RE: **Izzat Subdivision** (5 Lot Residential)  
NAA Tract 2, Unit 3, Block 3, Lot 31  
**Grading & Drainage Plan** for Preliminary Plat & Building Permit  
**PE Stamp: 10/29/13**

File # **C20/D069**

Based upon the information provided in your submittal received 12/16/2013, the above referenced plan cannot be approved for **Building Permit**.

The following issues need to be addressed on this Grading and Drainage plan for Preliminary Plat and Building Permit approval:

1 GRADING PLAN

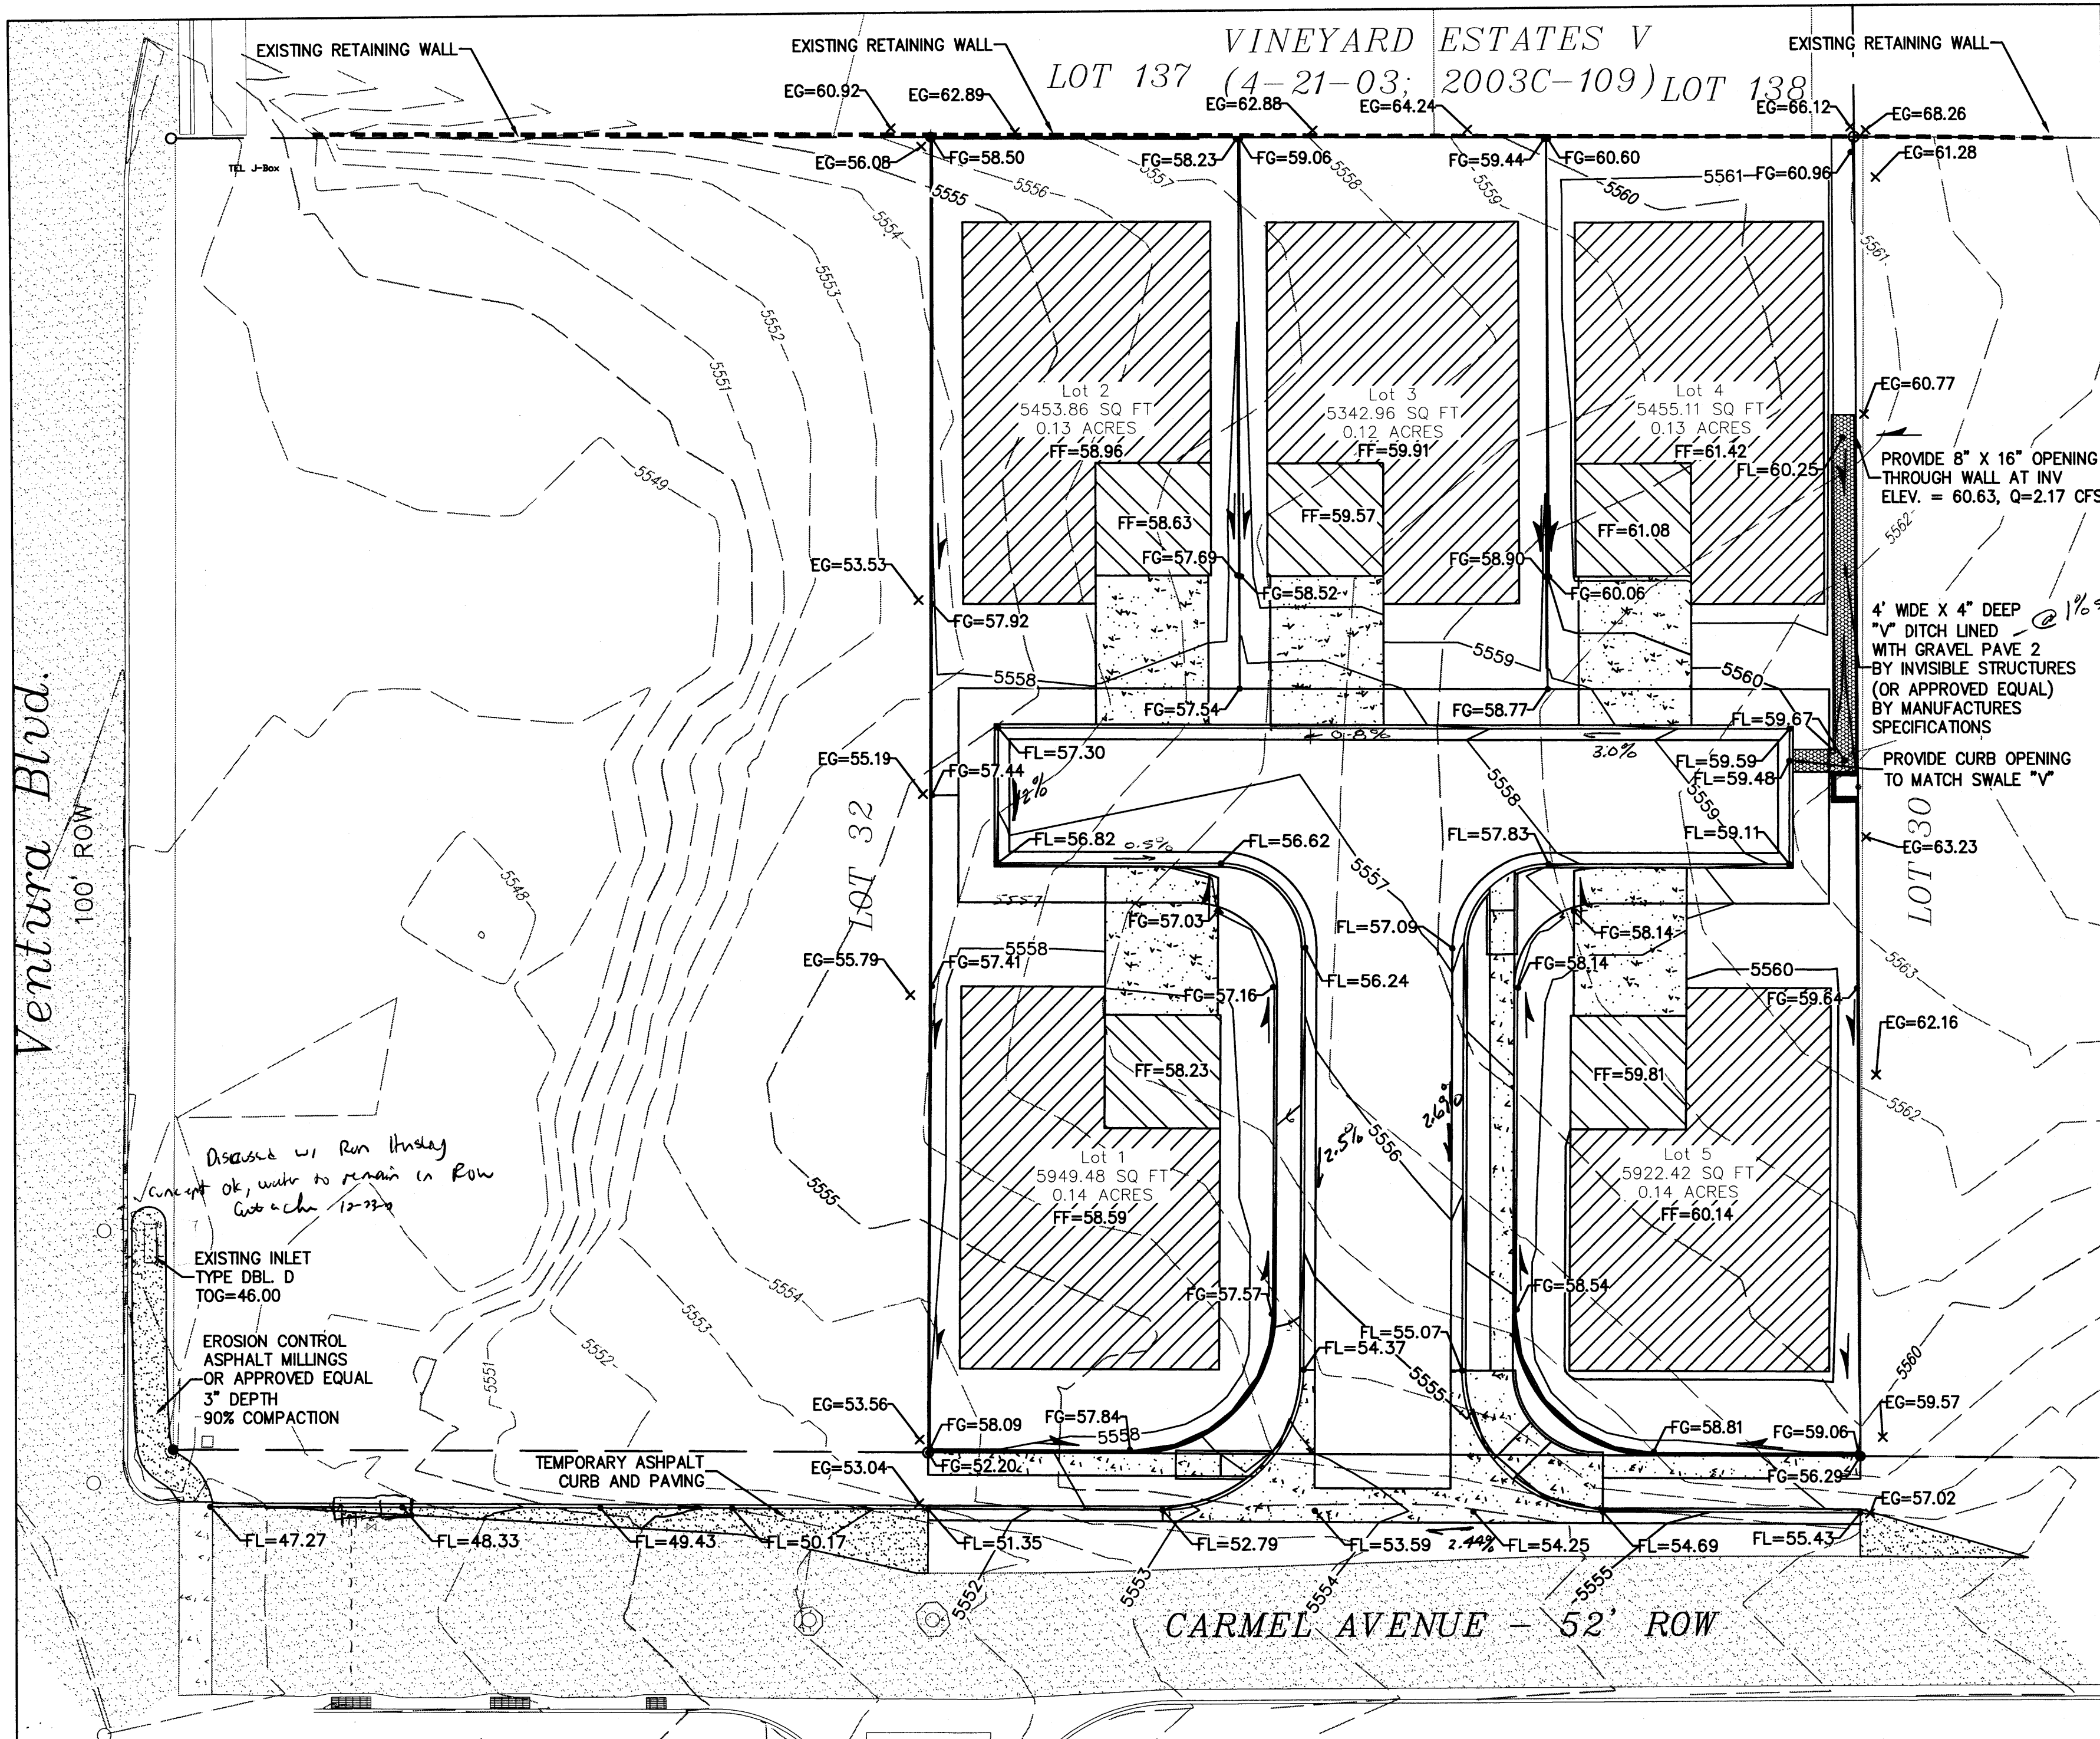
1. The location map should be corrected by darkening Lot 31 rather than Lot 32.
2. Runoff calculations that you provided did not consider offsite drainage in the adjacent Carmel roadway. My quick review of historic flows in Carmel found that existing flows from further east, plus proposed runoff from this site will exceed the capacity of the existing Double "D" inlet on Ventura, just north of Carmel. The resulting backup will result in ponding on the west side of Lot 32. Hence, the proposal to improve channelization of the rundown to that inlet is not sufficient.

3. To mitigate the issue identified in Item 2, this development will need to include the construction of one Type "Double C" inlet on the north side of Carmel, just east of Ventura, plus one stick of 18" RCP (Capped) and at least 6 LF of Standard Curb and Gutter on the upstream side of the inlet. There is an existing 18" Storm Drain pipe stubbed to that location by the Ventura Village development (CPN 399981).

4. Call out all proposed retaining wall limits on the plan view and provide Top of Wall and Bottom of Wall (or footing) elevations at critical points.

5. Clarify the intended drainage pattern in the "Tee" area of the site paving. Does the flow in the north gutter continue west, around the end of the tee, or does the gutter spill out across the tee to the south? I suggest an additional spot elevation in the gutter flow-line, in line with the Property Line between Lots 2 and 3.
